Lime Down Project

Comments to Applicant's Responses to written Summary of Oral Submissions at the Open Floor Hearing

Title:
Figure 11.3 Rev 4: Lime Down C1 Fluvial
and Surface Water Flood Risk Map

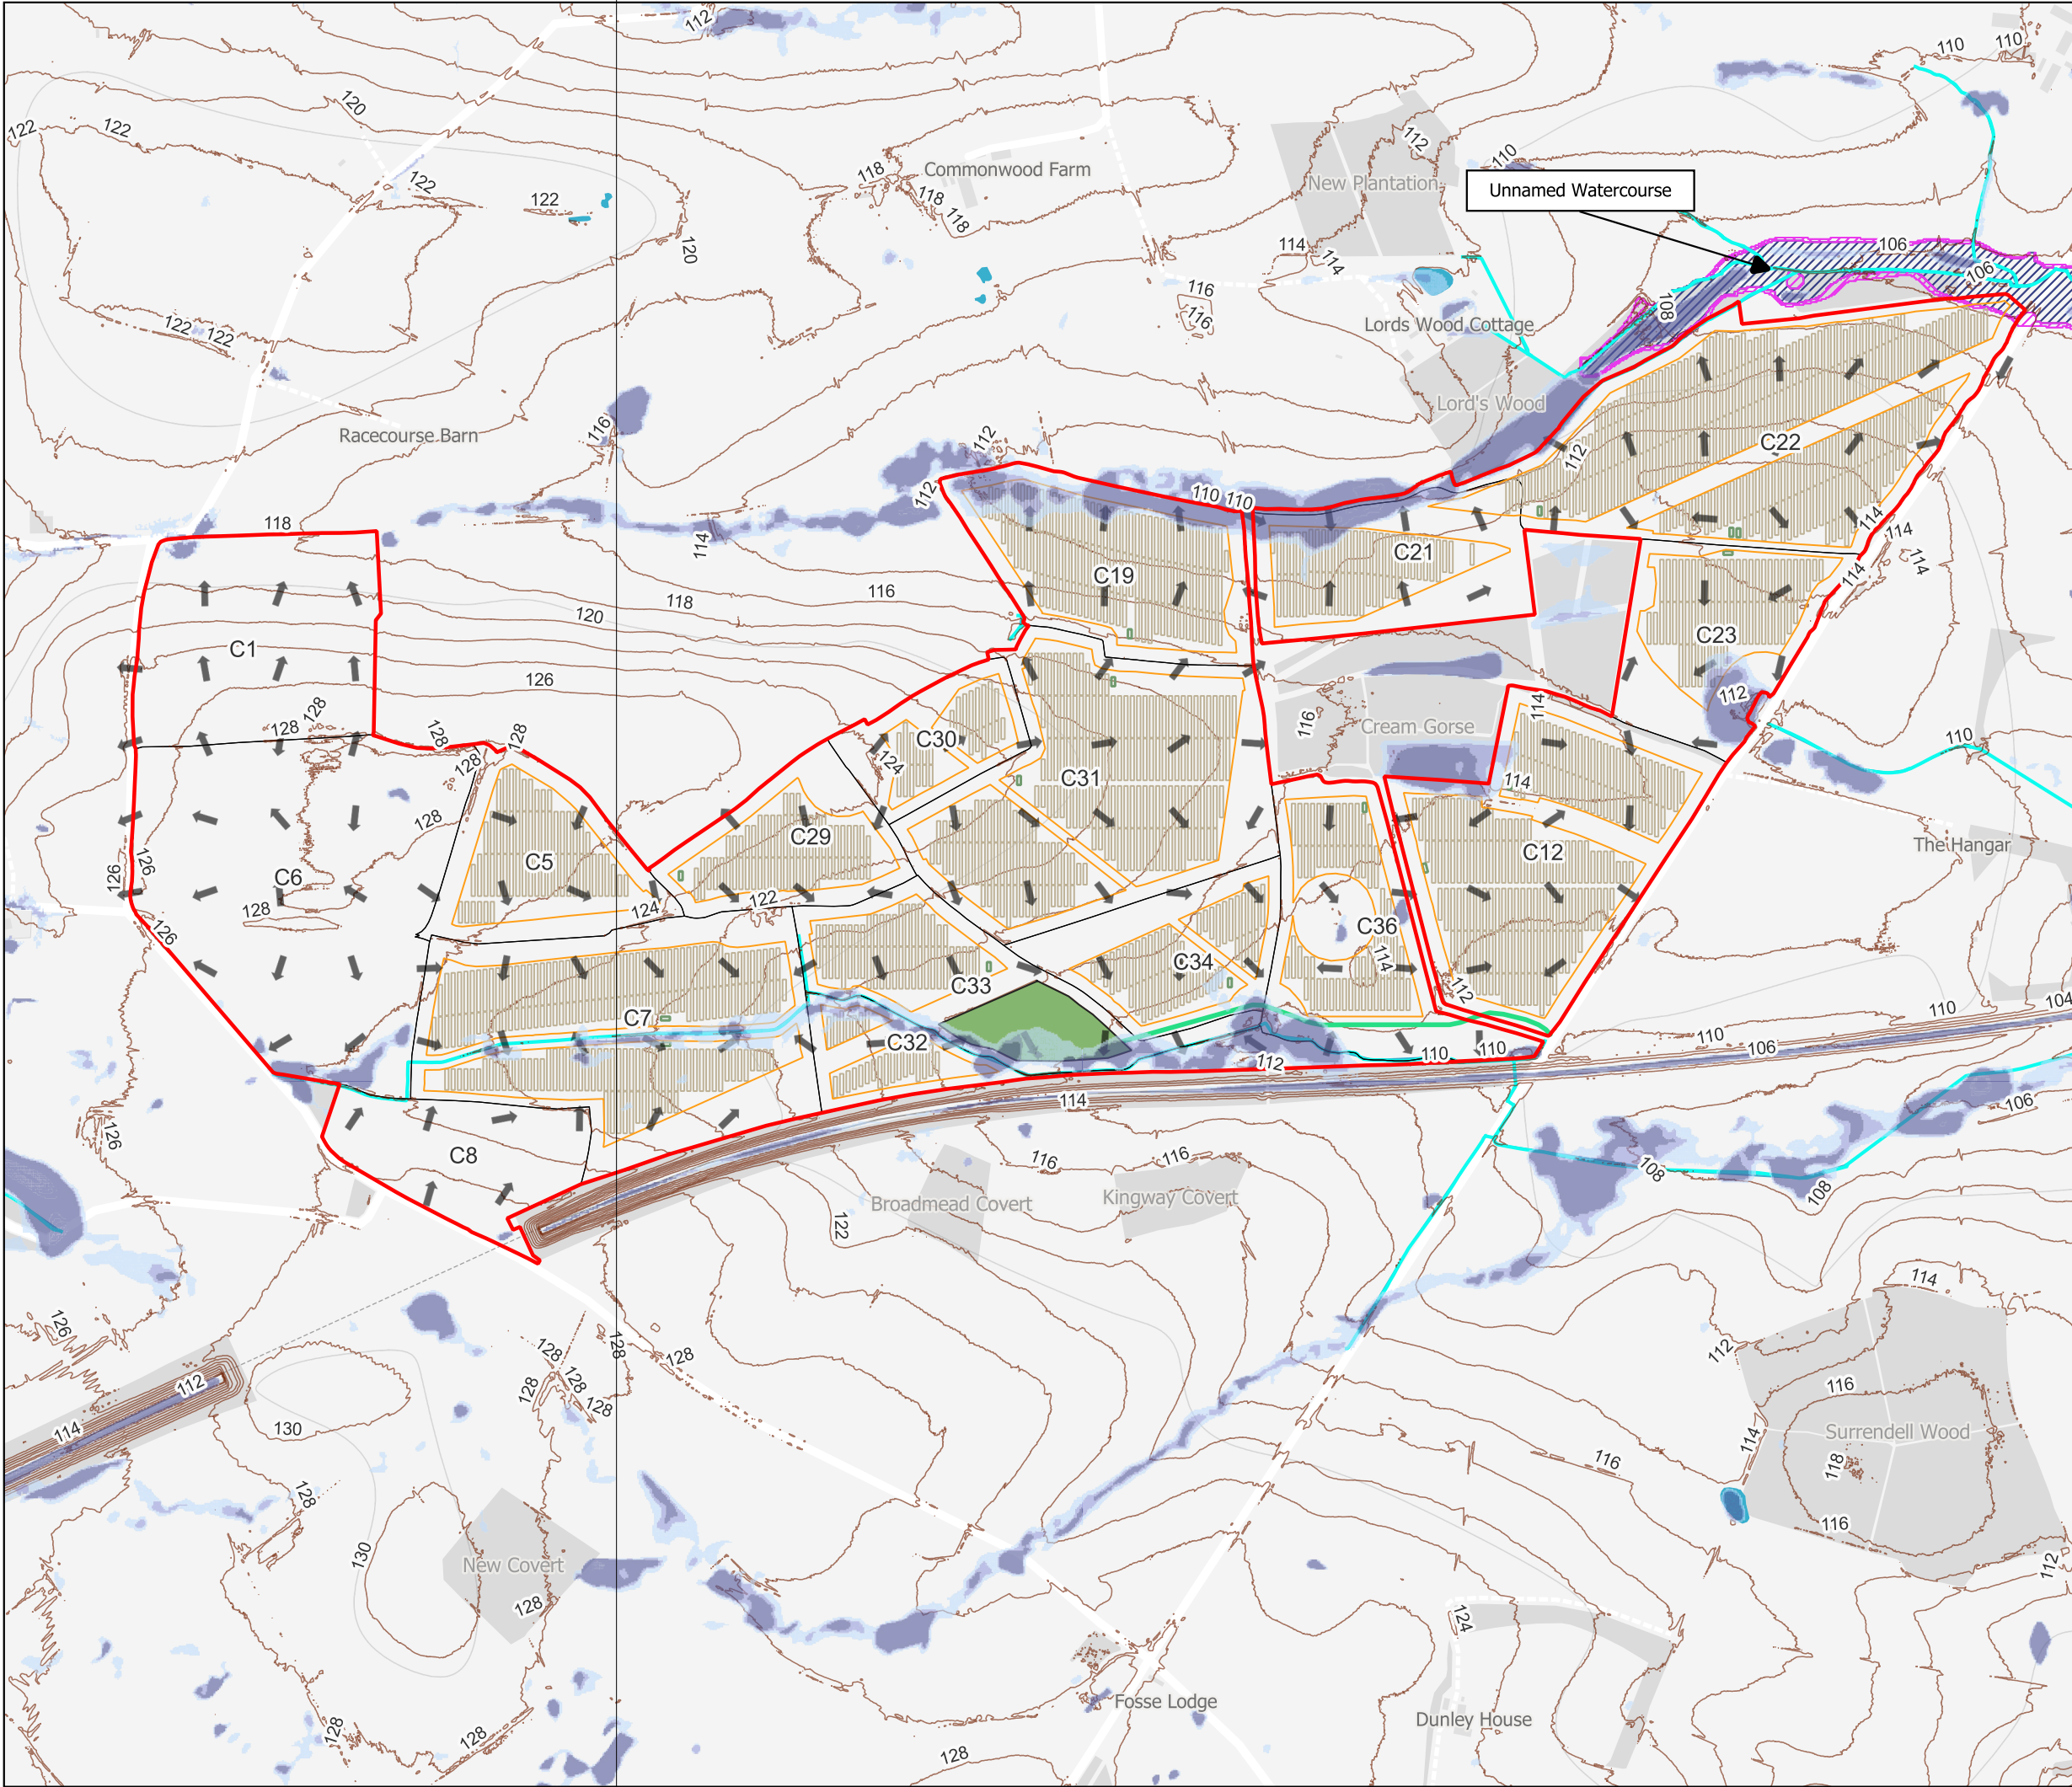
Ref	Applicants resume of original comment	Applicants Response	Comment to Response
GP-001	Mr. Philipps introduced himself as a local resident who lives on Mill Lane, Corston, and spends a lot of time in his garden which has a 300metre frontage to the Gauze Brook and bridleway MALW 51. He referenced Storm Bert in November 2024 which caused the Brook to flood 17 times that winter, with the increased runoff identified by Professor Skeffington which will increase the speed at which waters rise. This means that A429 bridge gets more easily overwhelmed, raising the flood level and increasing risk to Corston Residents. This would render stillborn and thoughts on flood alleviation by the local Council should Lime Down go ahead.	The Applicant notes Mr Philipps' comments regarding existing flooding from the Gauze Brook at Corston, including the flooding experienced during and after Storm Bert. The Applicant does not dispute that Gauze Brook is an existing source of flood risk during high flow conditions. The relevant question for the DCO is whether the Scheme would materially increase flood risk to Corston or worsen flooding at existing downstream structures, including the A429 bridge. The Applicant does not agree that the Scheme would increase runoff in a way that would cause Gauze Brook to rise more quickly, increase flood levels at Corston, or undermine potential future flood alleviation measures. The flood risk assessment for Lime Down D has been informed by hydraulic modelling of Gauze Brook. The submitted assessment does not identify a material increase in flood risk to Corston as a result of the Scheme. Solar PV panels would be elevated above ground and would not operate as impermeable hardstanding or as a connected drainage catchment. Rainfall would continue to drain to ground beneath and between the panel rows. Formal impermeable infrastructure would be subject to controlled drainage, attenuation and discharge controls through the relevant FRA and Drainage Strategy and the detailed drainage	Environmental Statement Volume 3, Flood Risk Assessment and Outline Drainage Strategy – Lime Down D / BESS addresses the flood risk within the confines of Lime Down only and all the maps are limited to the site and in particular do not address any potential impact down stream of D13 or D14 (which are stated as being in flood zones 2/3) except for paragraph 2.4.4 which states: "any potential surface water flooding arising at or near to Lime Down D would be directed eastwards, away from Lime Down D, following the local topography and the watercourses." Furthermore 2.9.1 states: "It can be concluded that the risk to Lime Down D from all sources of flooding is Negligible to Flood Risk". Downstream of D13 & D14 the available flood plain narrows substantially and as Gauze Brook enters Corston it is approximately 60m wide between the 75m contours with the river bank at 70.58m AOD some 4m below the level of D14 where the 75m contours are some 500m apart according to OS Maps. There appears no consideration of the flood risk to Corston as implied in the applicant's response. The water course further narrows to pass under the A429 bridge. It is noted that the recommendation is that the panels be located 600m above the ground presumably to ensure that the panels themselves are not impacted by flood water. The fact that the run off from the panels would be concentrated to the bottom edge of the panels suggests that there would be an impact on permeability below these strips – Has any study been provided as to the potential impact of this aspect? Paragraph 2.3.21 provides for wide mesh fencing to be used in Flood Zone 3 areas which would include D14. The fields

design secured under Requirement 11: Surface Water Drainage of the Draft DCO [REP3-005]. Construction phase runoff, sediment mobilisation and soil compaction risks would be managed through the Outline CEMP [REP3-092] and Outline Soil Resources Management Plan [REP3-098]. On this basis, the Applicant does not agree that the Scheme would materially increase flood risk to Corston or make flooding at the A429 bridge more severe.	downstream of D14 are fenced with conventional sheep netting against which there is a substantial build up of debris every time Gauze Brook floods; causing water to back up further. A mesh size larger than sheep netting would impact the applicant's ability to exclude deer etc from the site.
GP-002	There are on average 20 to 30 groups passing by the garden daily and perhaps 100 on a summer's weekend, with families, dog walkers, cyclists, hikers and horse riders. The footpath is set to close, eroding the main benefit of MALW 51 and cutting off 45-minute circular routes to Mill Lane	MALW 51 will remain open throughout the lifetime of the Scheme and will connect to HULL7 to the west. Maintenance of the PRow surface, furniture and waymarking within land under freehold acquisition by the Applicant is their responsibility to maintain, and is secured through the Outline Public Rights of Way and Permissive Paths Management Plan [REP1-104] by Requirement 16 in Schedule 2 to the Draft DCO [REP3-005].	The Applicant has taken the comment re footpaths out of context. It was acknowledged that MALW51 will remain open throughout albeit enjoyment of it will be decreased. MALW51 is relatively short but it is important, its main benefit being that it leads into HULL7 and HULL6 to provide circular routes back to Corston. It would appear that both HULL7 and HULL6 will be subject to closure removing the prime benefit of MALW51
